Ribble Valley Borough Council
Housing & Development Control

Application no: **3/2021/1235**

Address: **Cunliffe Moss Farm Saccary Lane Mellor BB1 9DL**

Proposal: **The change of use of agricultural land to dog walking area, the erection of building to accommodate a dog grooming/rest area and the erection of a field shelter**

Title: Existing and Proposed Site Plans.	
Drawing No: AIN/798/3080/02	Drawn: PF
Client: Mr M Ainsworth	
Date: 29.11.2021	Scale: 1:500 @ A1
Amendments:

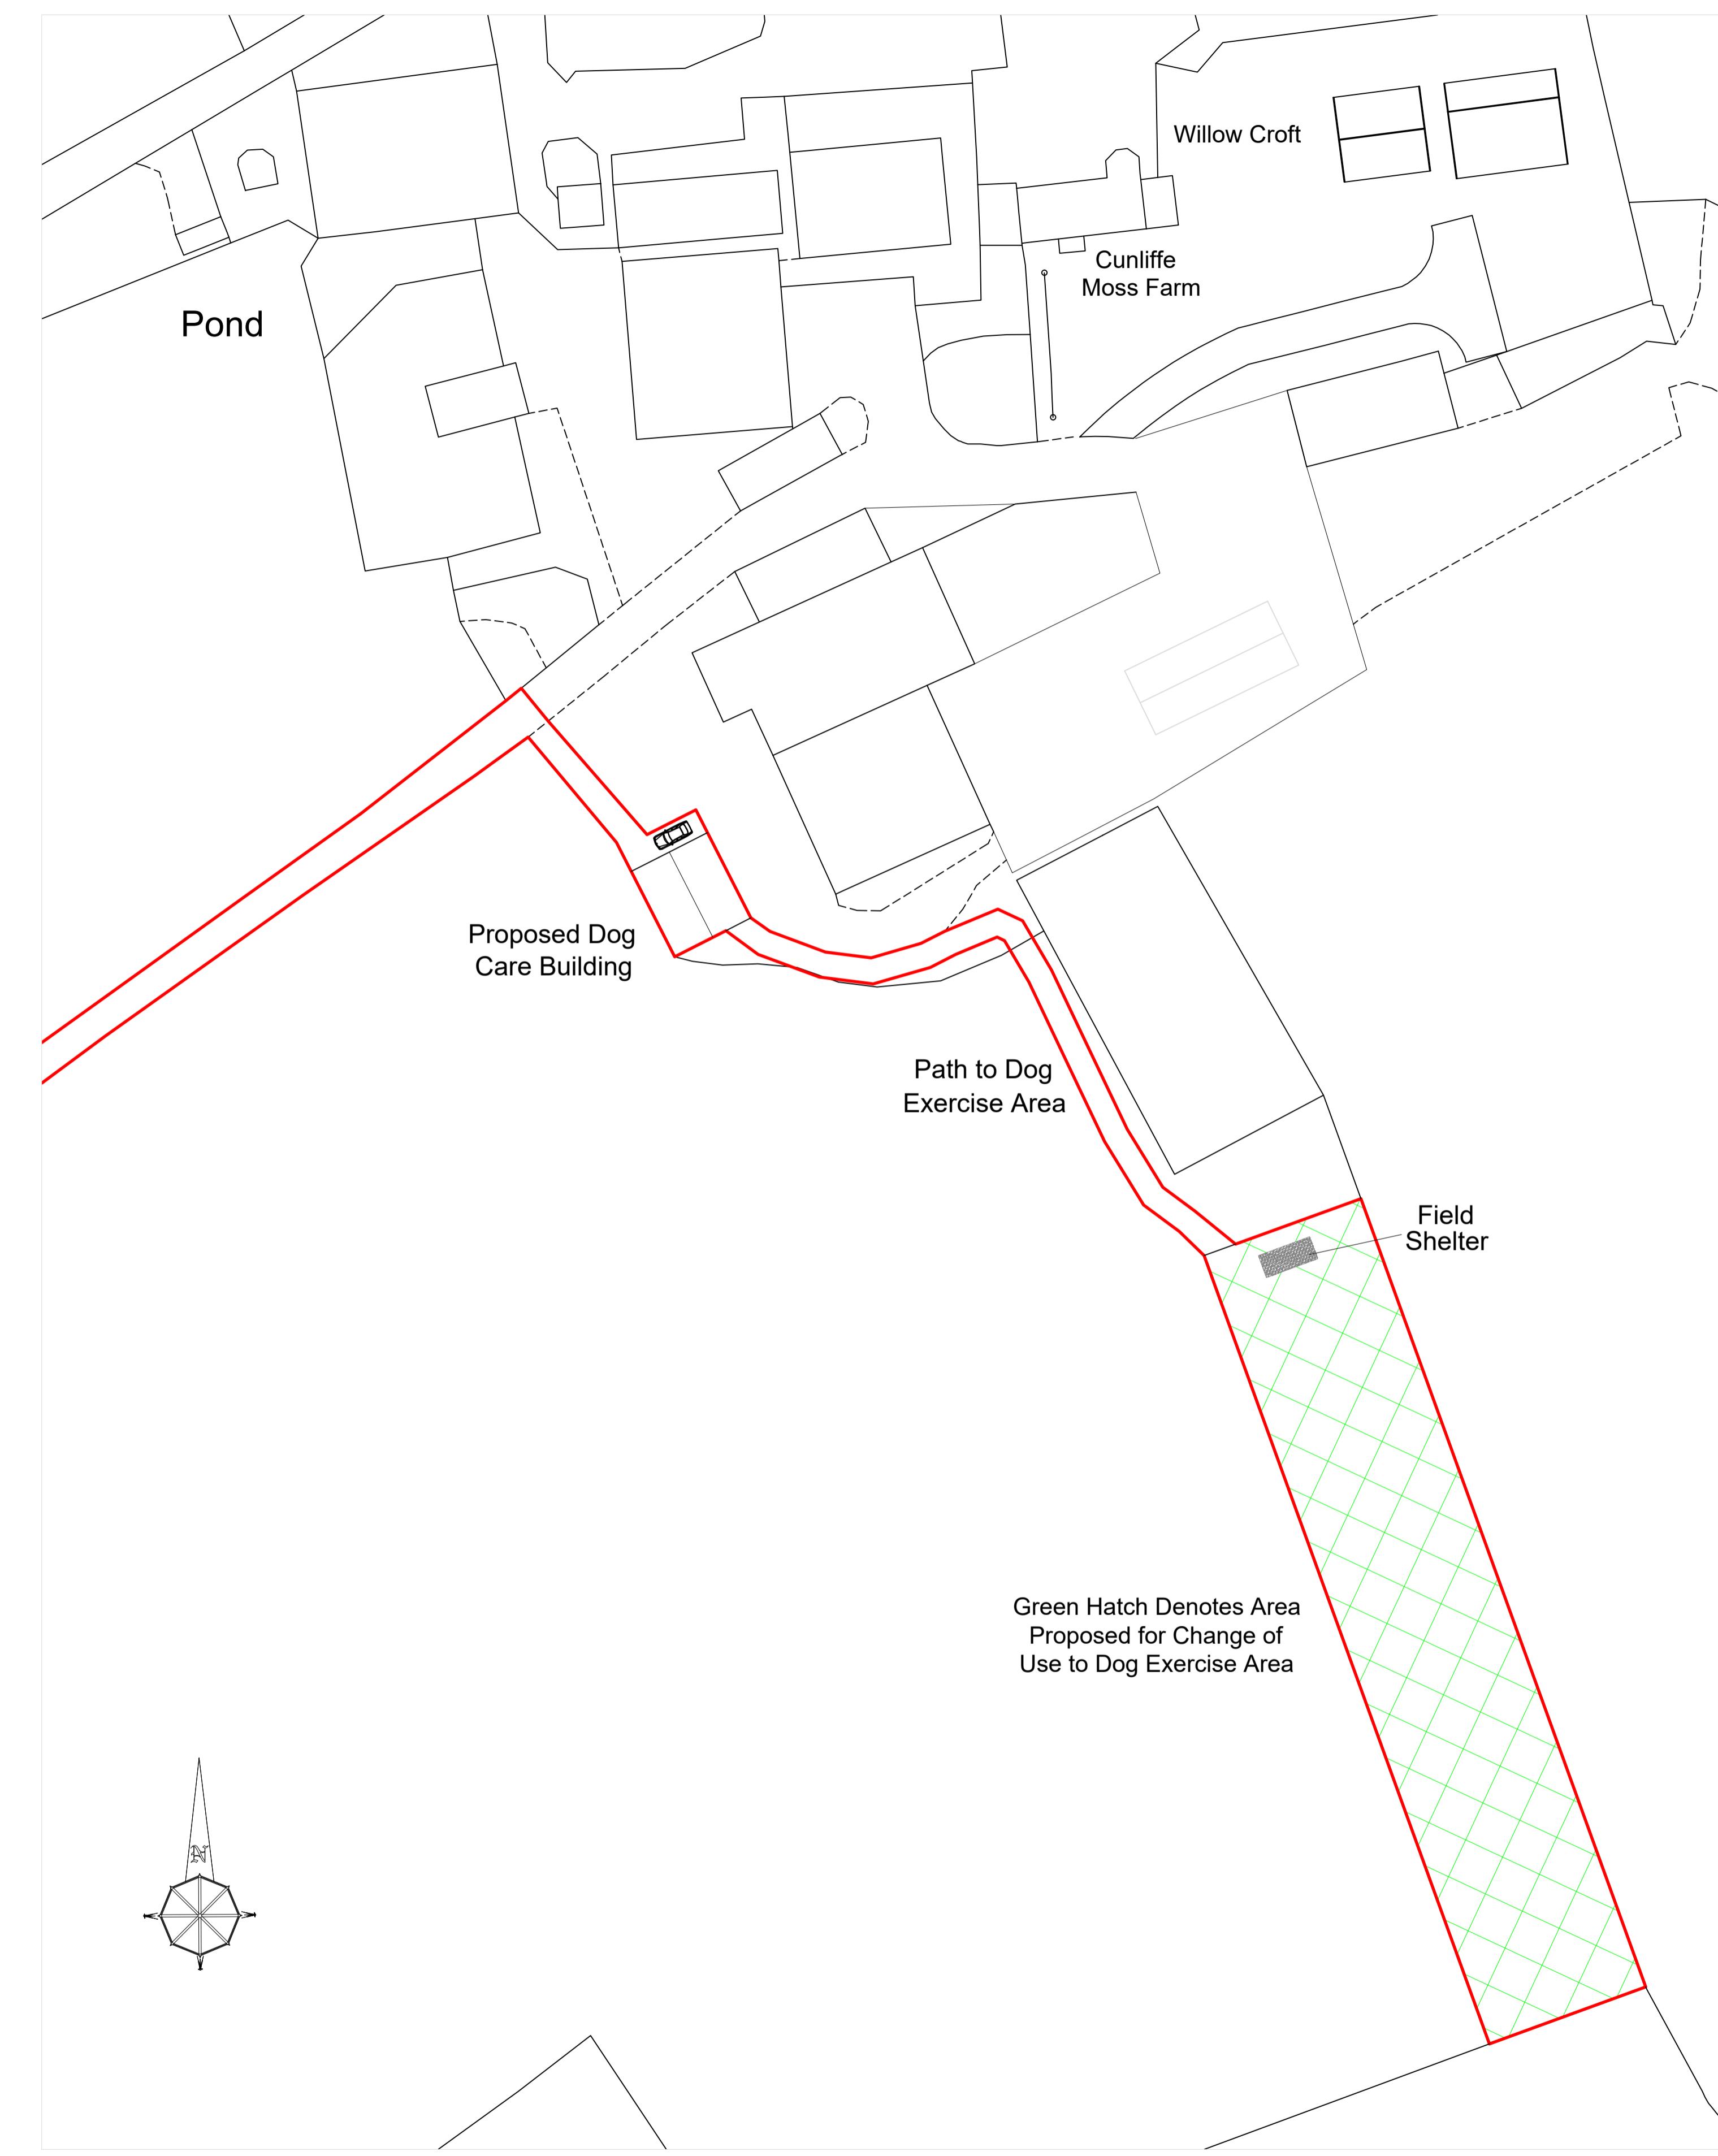
The LHA have reviewed GHA drawing number Ain/798/3080/02 titled " Existing and Proposed Site Plans" and are satisfied that the proposed parking arrangements complies with the Joint Lancashire Structure Plan.

1. The development hereby permitted shall not be occupied until such time as the parking and turning facilities have been implemented in accordance with GHA drawing number Ain/798/3080/02. Thereafter the onsite parking provision shall be so maintained in perpetuity.
